Our Ref: ID 1789
Your Ref: SSD-41306367

08 December 2022

Environmental Impact Assessment for New Public School Gregory Hills

Figure 39 Flood Impact Map (source Bennett and Trimble) Not to scale

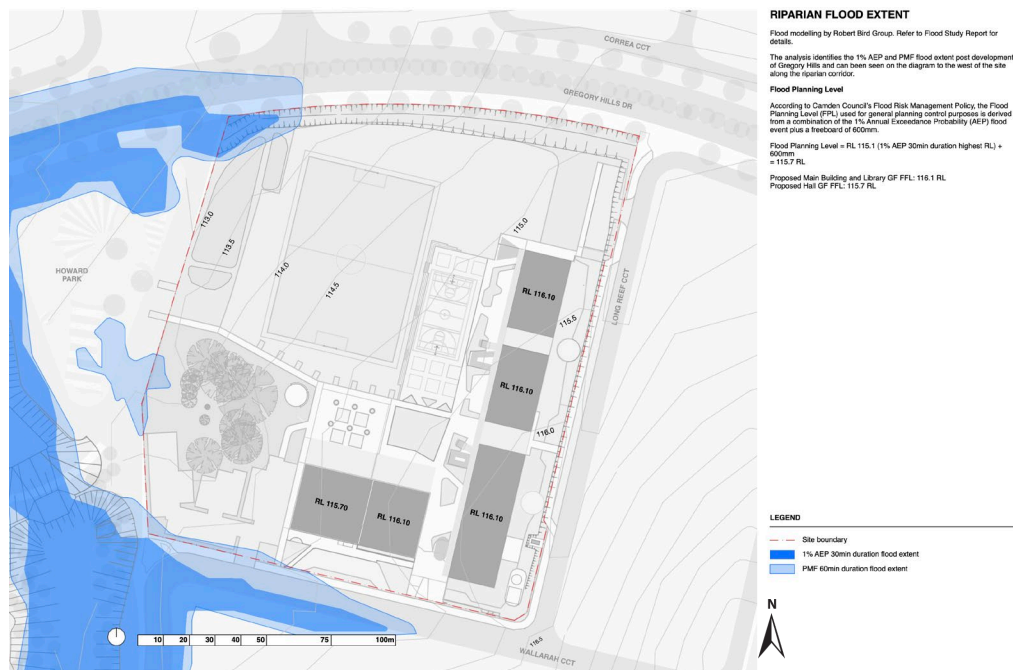
The flood impact to the site up to a PMF is noted as minimal in the Flood Study, affecting the site boundary only and not the proposed buildings. Most of the site is above the PMF.

It is noted that many of the adjacent roads are impacted in a 1% AEP event (based on the flood study provided). However, it appears that access may still be available via the small Long Reef Circuit and Wallarah Circuit (east), if required.

The Flood Study should be amended to reflect that the preferred strategy is early closure of the school, prior to the onset of flooding on any adjacent roads. An alternative strategy would be for the students to move away from the floodwater, as most of the school is above the PMF.
